## City of Albuquerque Stormwater Construction Site Inspection Report

General Information					
ESC File No.	G11E069	Project Name:	Coors Pavilion at St Josephs		
NPDES Id. No.	NMR10052A	Location:	Coors Blvd and St Josephs Dr NW		
7/21/2023	Owner	Contractor			
Operator	Red Shamrock 4 LLC	Skarguard Construction LLC			
Contact name & title	Joshua Skarsguard	Jason Skarsguard			
e-mail	josh@skarsguardfirm.com	jason@skarsco.com			
Contact Phone #	505-262-2323	505-803-3757			
COA Inspector	Chancellor English	Start/End Time:	930am		
Construction Phase:	Grading/stockpile				
Type of Inspection:	Regular	Storm Event	Post Storm Event >0.25"	311/Complaint	Follow Up
Weather at time of inspection?	Clear		Temperature: ~	90	
Estimated date of last storm 0.25" or greater	5/22/2023

C-1

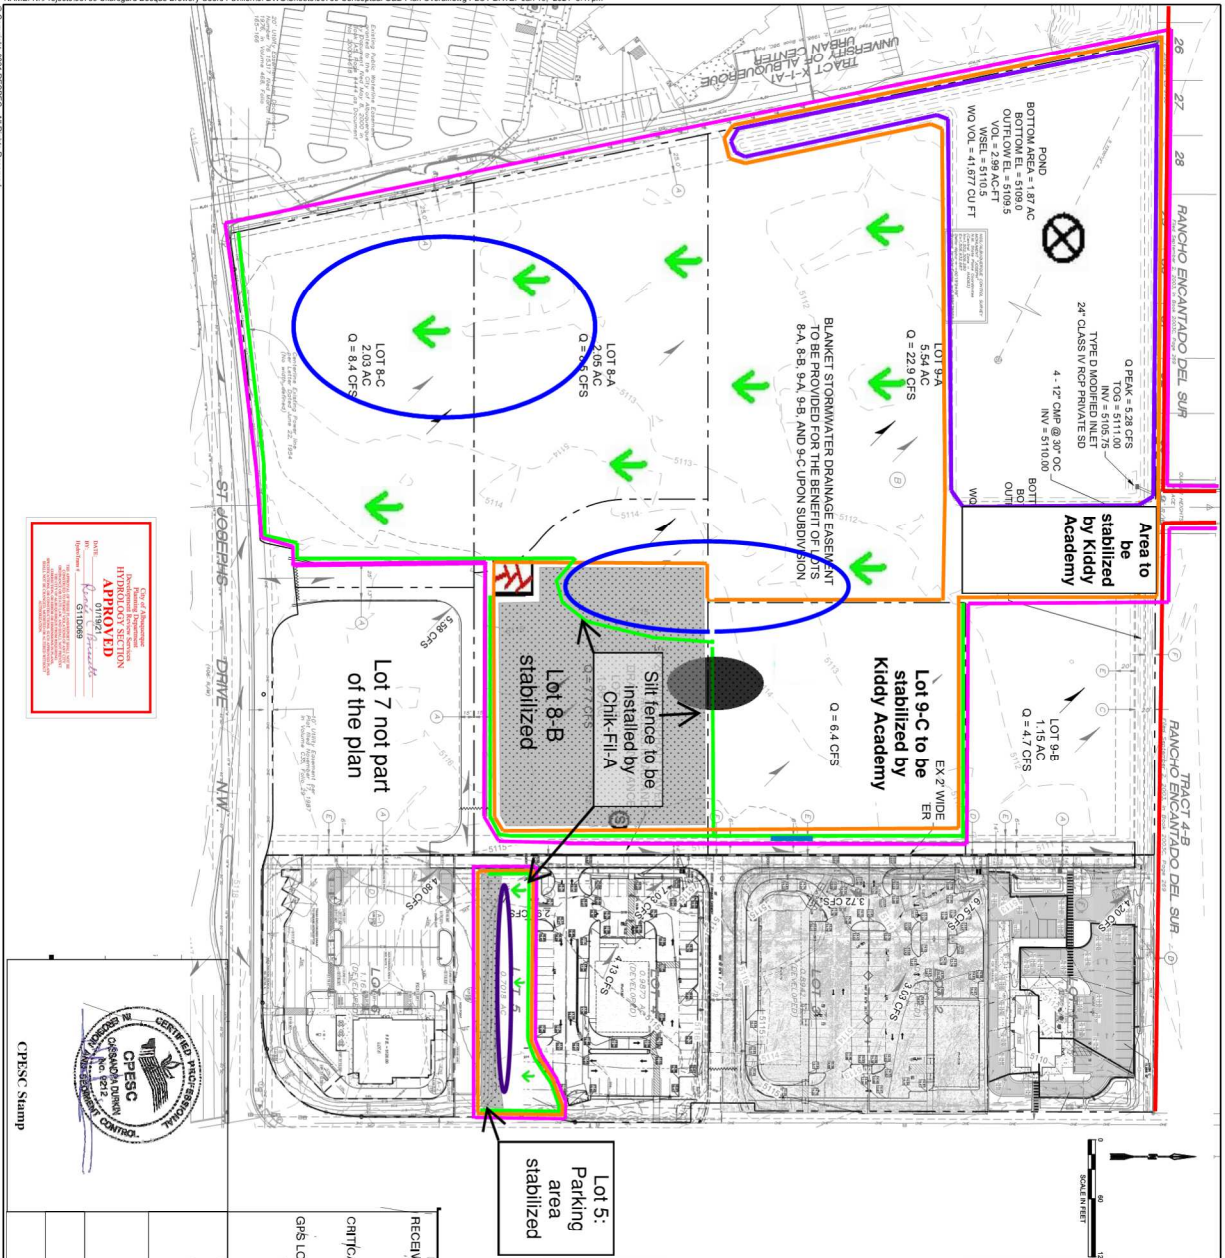
3	BMP - Several areas of the perimeter silt fence have collapsed or degraded and are in need of maintenance. Required mitigation: Ensure that perimeter controls continue to work effectively as per CGP Section 2.2.3.				
4	Stabilization - Stockpiles on Lot 5 and southwest corner are exposed and not stabilized or covered. Required mitigation: Manage stockpiles or land clearing debris piles composed, in whole or in part, of sediment and/or soil as per CGP Section 2.2.5. Section 2.2.5.c states that for piles that will be unused for 14 or more days, you must provide cover or appropriate temporary stabilization consistent with Section 2.2.14.
